RE: Silverado Ranch PUD Final Plat Phase 1 (SF1811)

This letter contains the Applicant's (Silverado Ranch, LLC) responses to comments received from various El Paso County (EPC) departments as well as comments received from utility companies and other agencies regarding the proposed Silverado Ranch PUD Final Plat Phase 1. Note that agencies with "no comments" have not been included in this letter. The Applicant's responses can be found in italics below each comment received.

SILVERADO RANCH
MARCH 29, 2018
PROJECT 16093
SHEET 1 OF 1

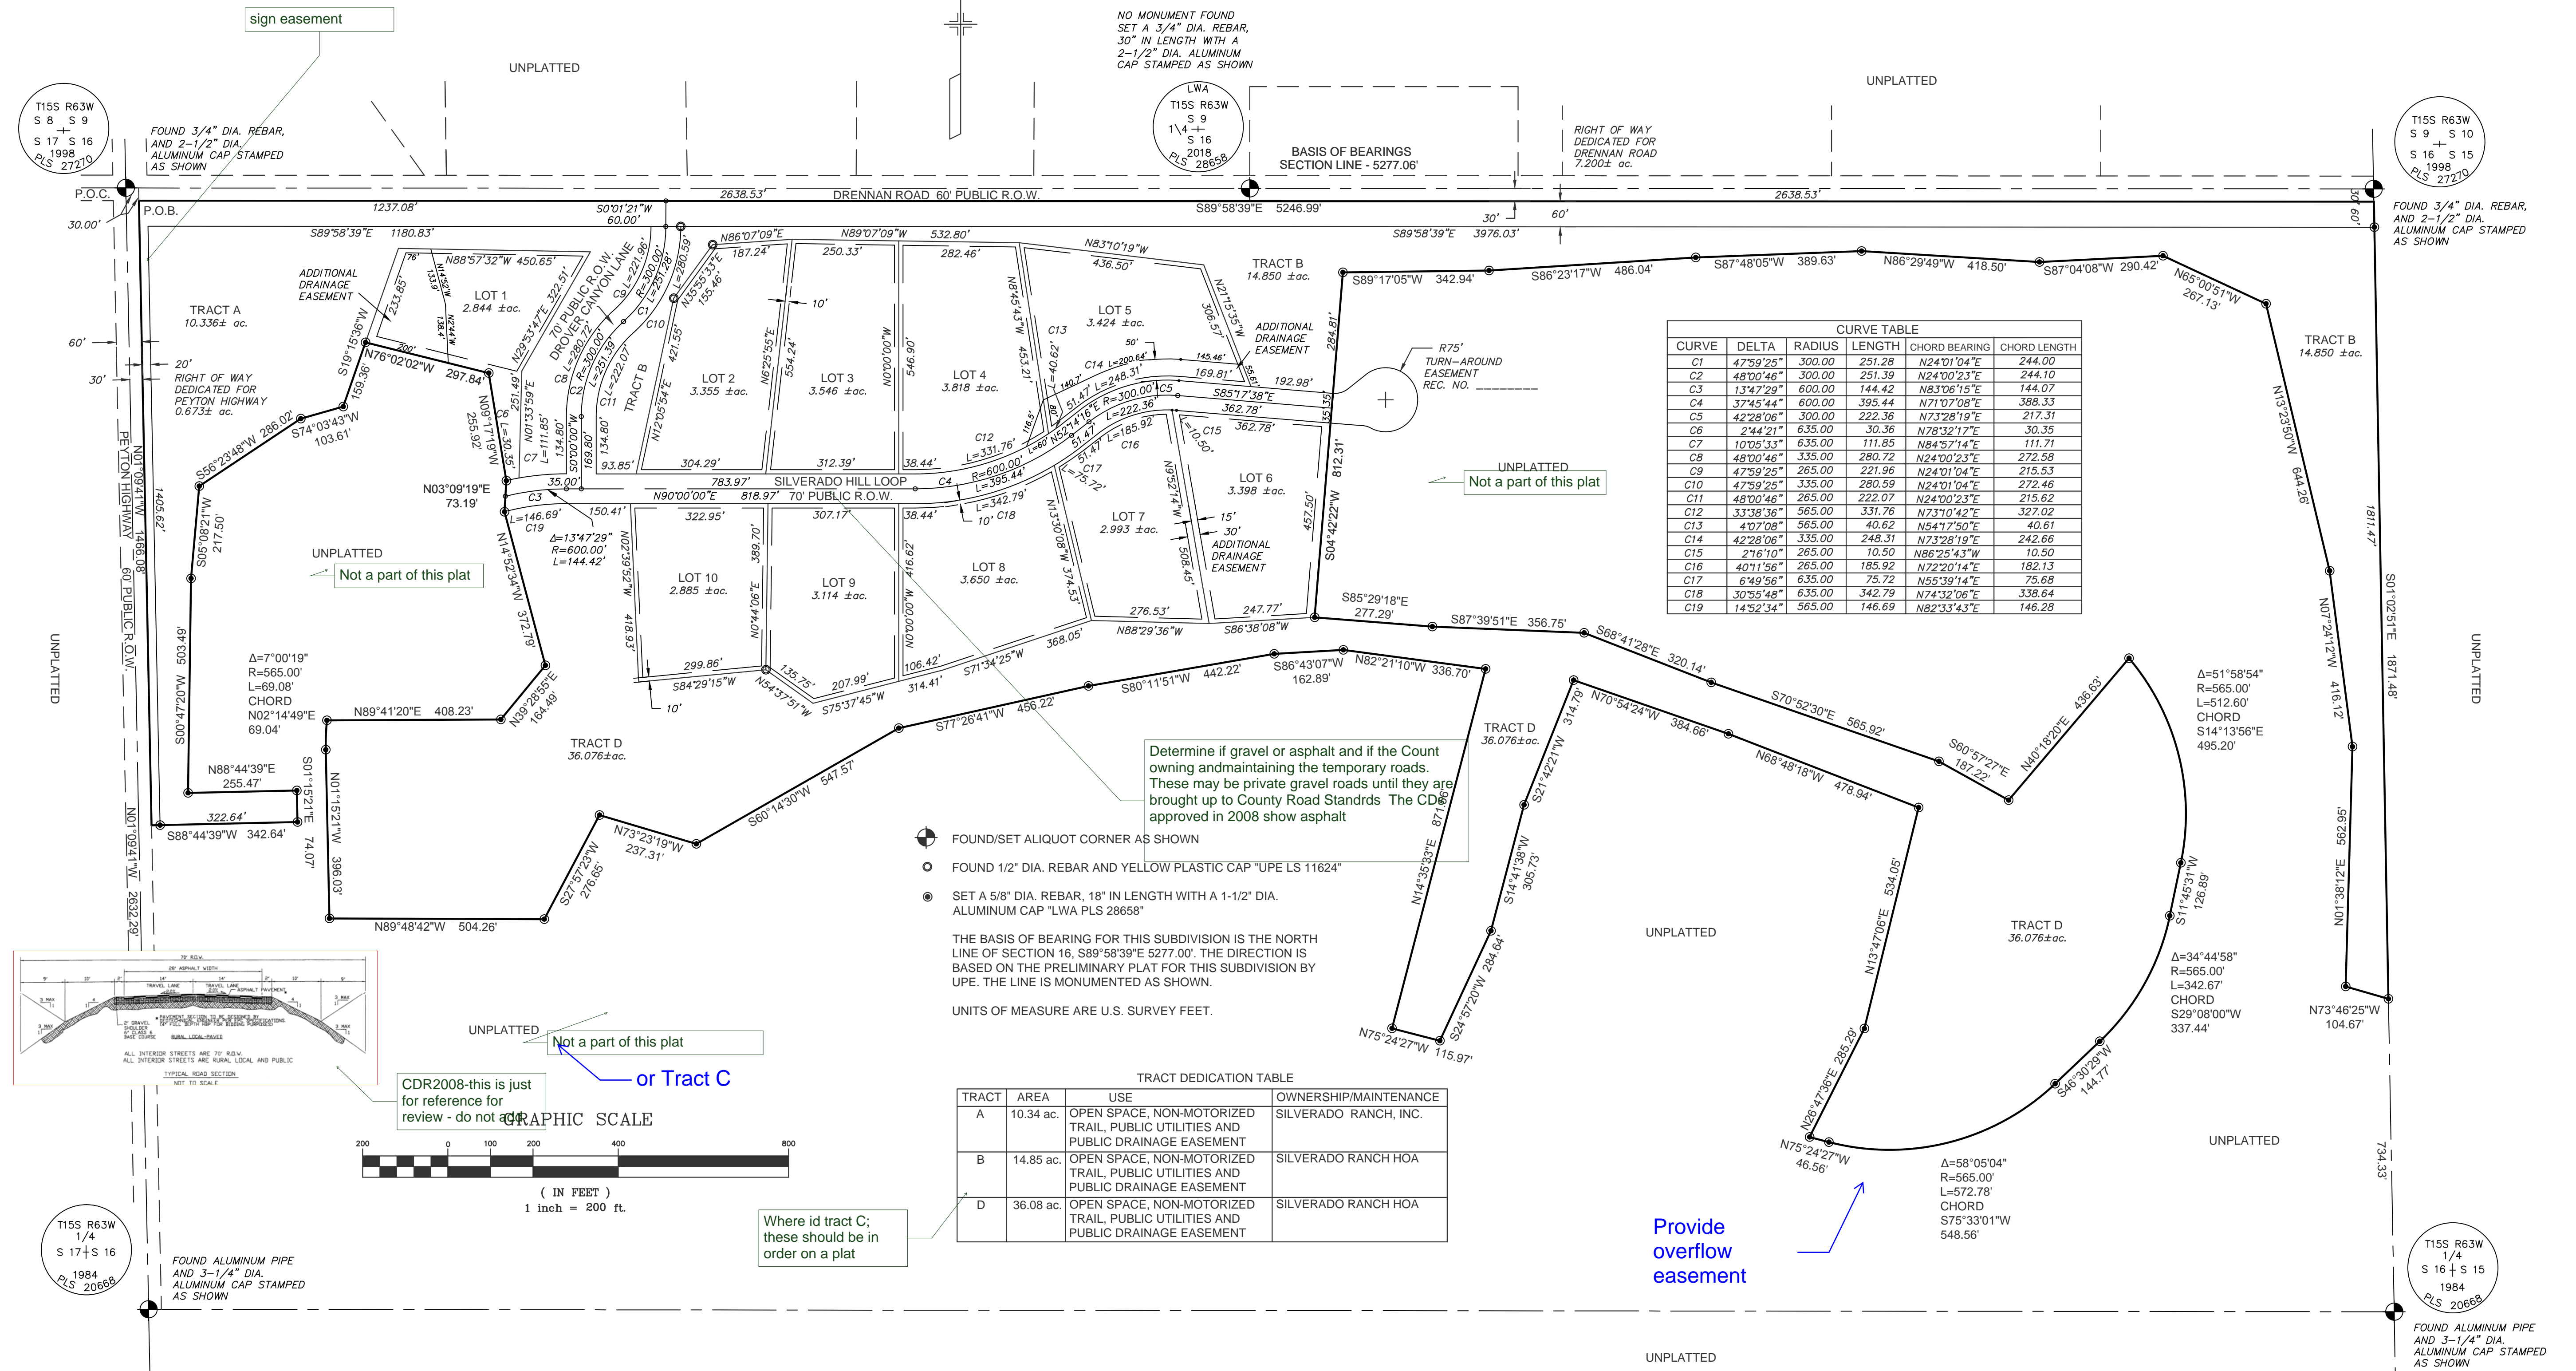
1. Update plat note #17.
2. See Final Plat redlines for additional minor corrections and clarification of these comments.

Response: Engineering Department comments on the Final Plat have been addressed on the revised Final Plat plans submitted with this letter.

1. See minor redlines.
2. Provide a drainage easement for the retention pond spillway area. The easement form can be the same as that of the cul-de-sac, with purposes specified.

1. *Redline comments have been addressed in the submitted revised FDR.*
2. *A drainage easement for the retention pond spillway area has been added to the Final Plat.*
